**Oakdale West Industrial Estate-Mod-1 (SSD-7348-Mod-1)
Request for Response to Submissions**

Chris Ritchie
Director
Industry Assessments

Department Comments

Title
CUT/FILL PLAN

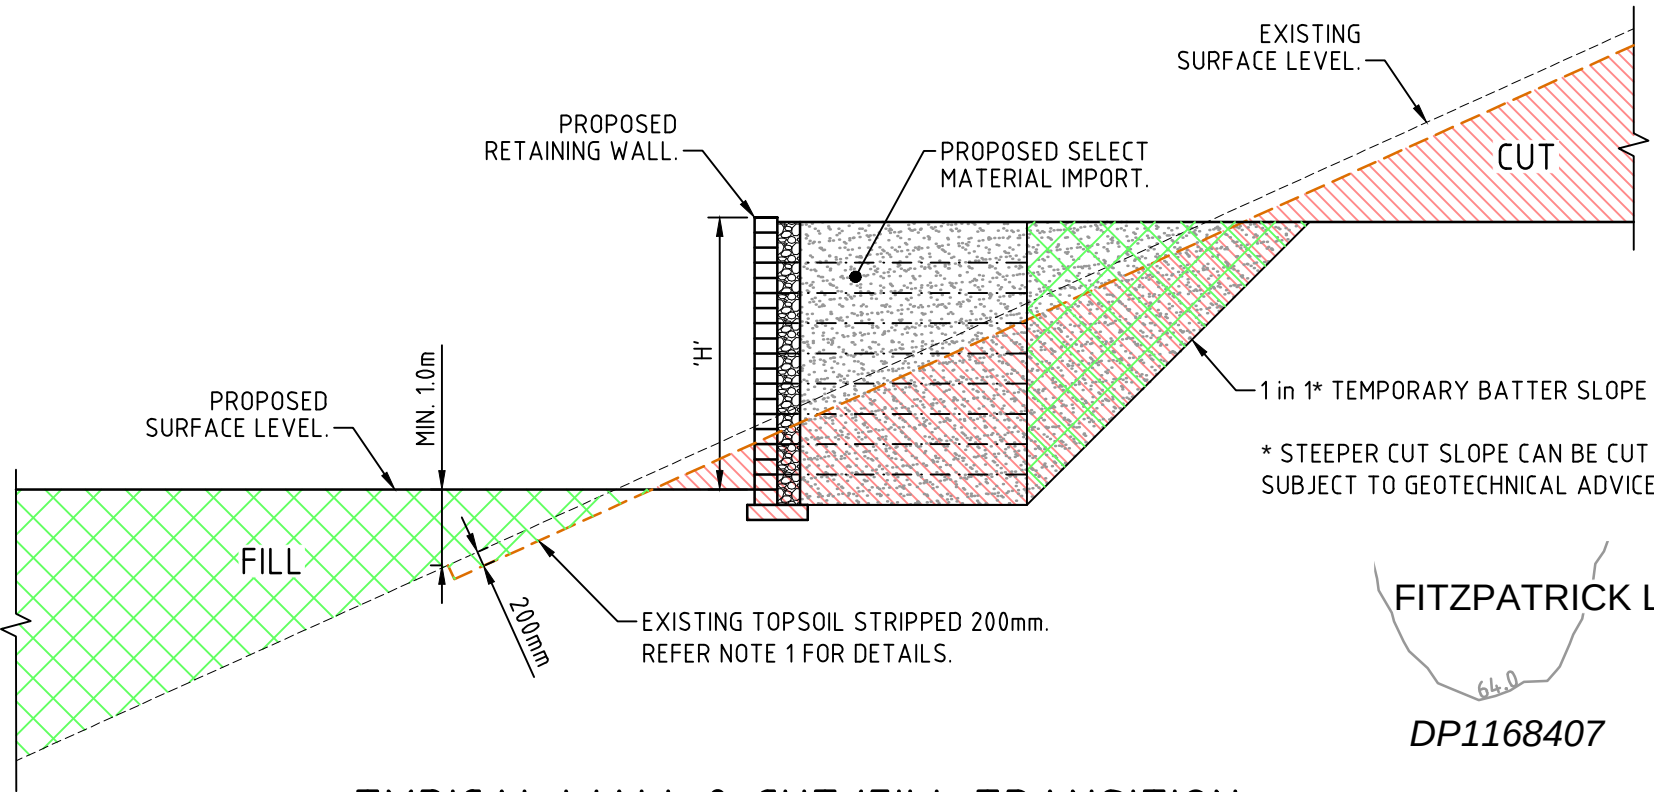
1. The proposed modification involves the increase of the Precinct 2 building pad level height by 2 metres (m) to facilitate the sewerage servicing of Precinct 2. The Department notes Council have stated it is unable to support the proposed increase in pad level height in its submission made on the modification application. The Department requests that the proposed sewerage design be revisited to reduce the increase building pad level height of Precinct 2 and provide detailed justification for the final pad level height.

2. The Modification Report prepared by Urbis describes the development as only modifying the pad levels of Precinct 2 however, Table 3 (see below) of the Modification Report provides the net changes in cut and fill across each precinct of the Oakdale West Estate. The Modification Report should be updated to concisely describe all changes being sought under this modification.

3. In respect to the comment above, the Department requests that changes to all building pad level heights be confirmed for Oakdale West site.

Title
TYPICAL SECTIONS SHEET 1

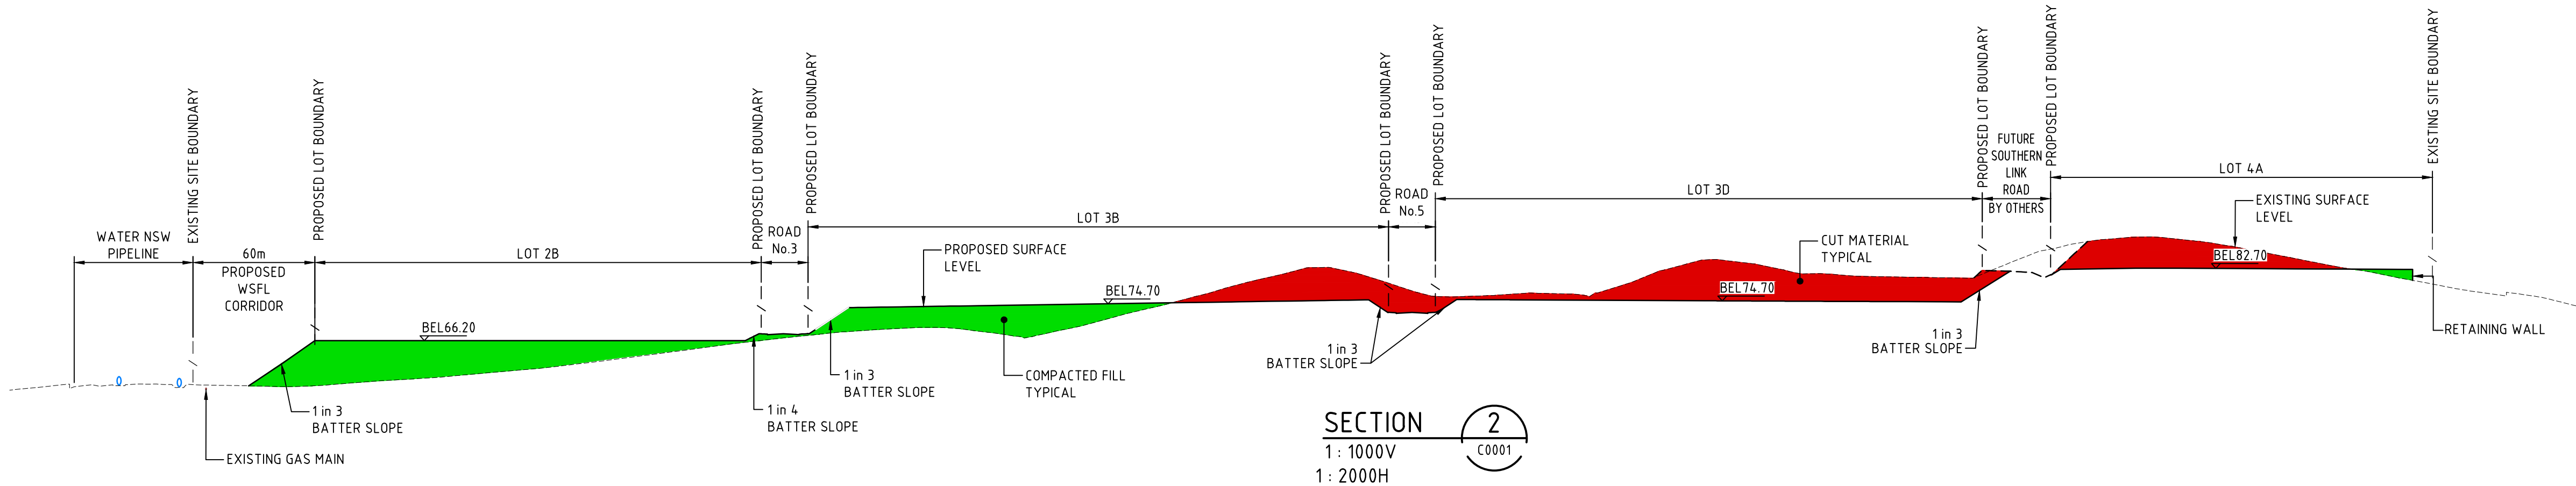
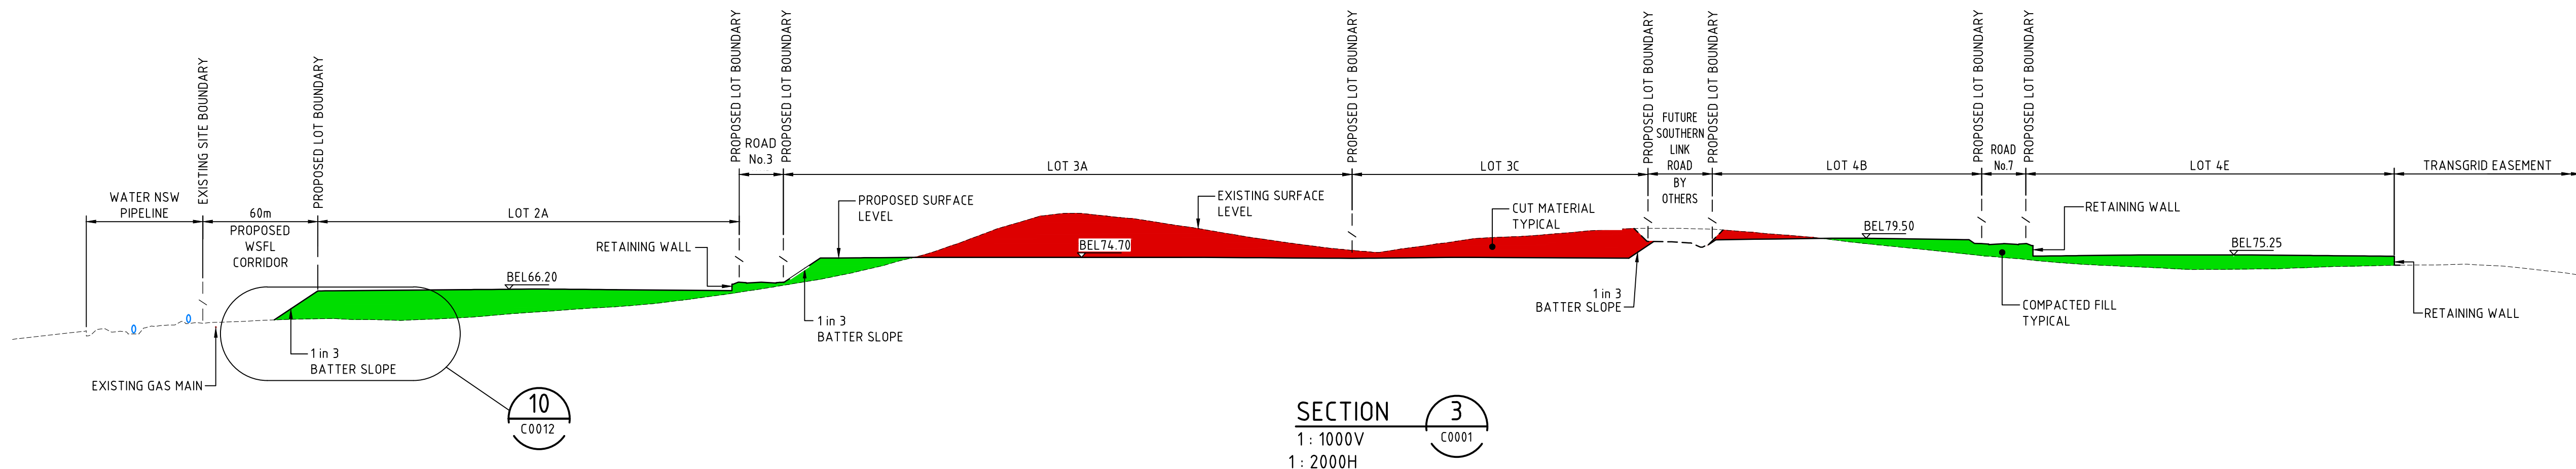
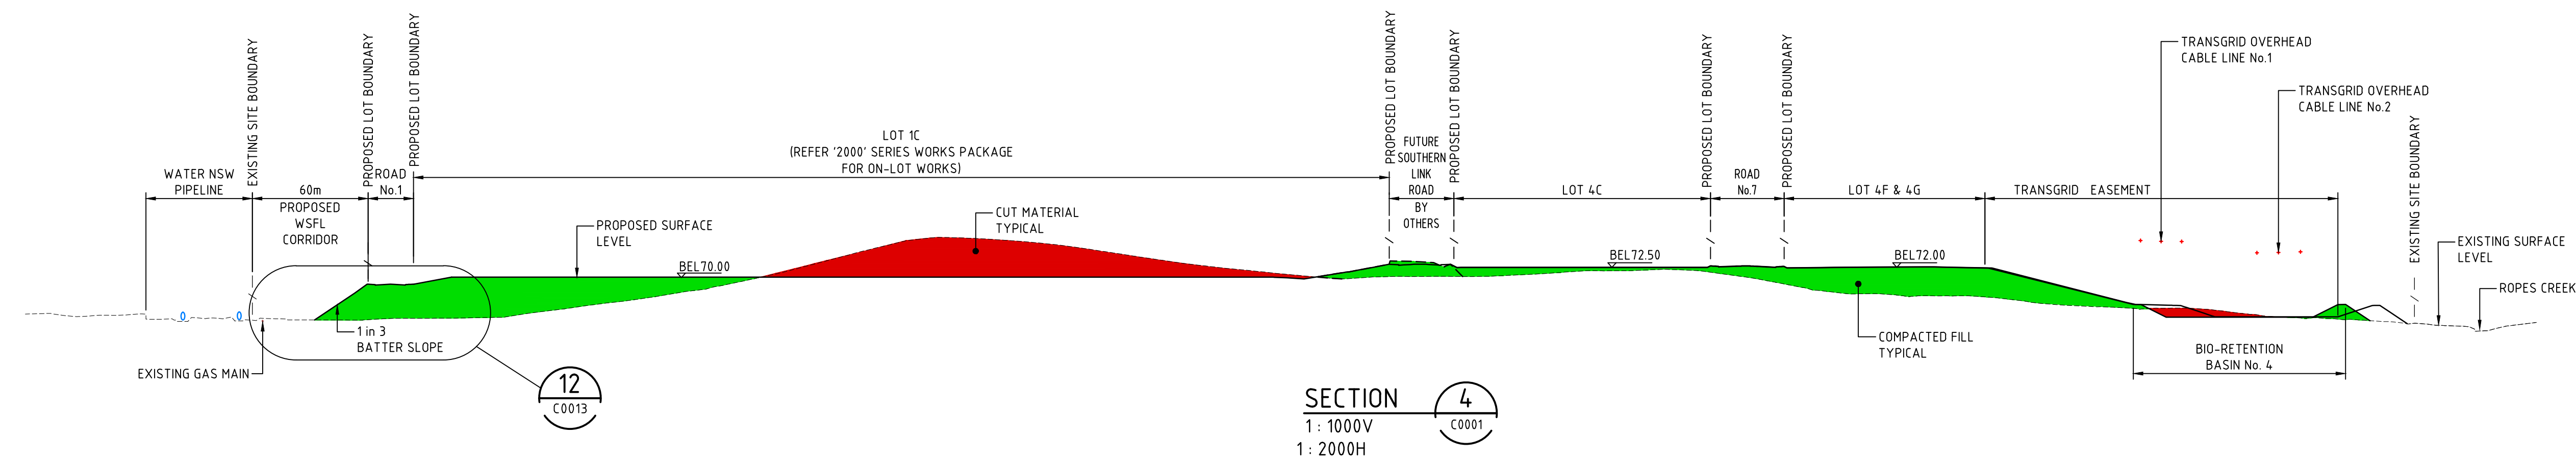
4. The Modification Report should confirm if the increase in pad level height will result in changes to the height and slope of the western boundary landscape buffer. Furthermore, the Modification Report and Visual Impact Assessment should clarify if any changes to the western boundary landscape buffer have been considered in the impact assessment.
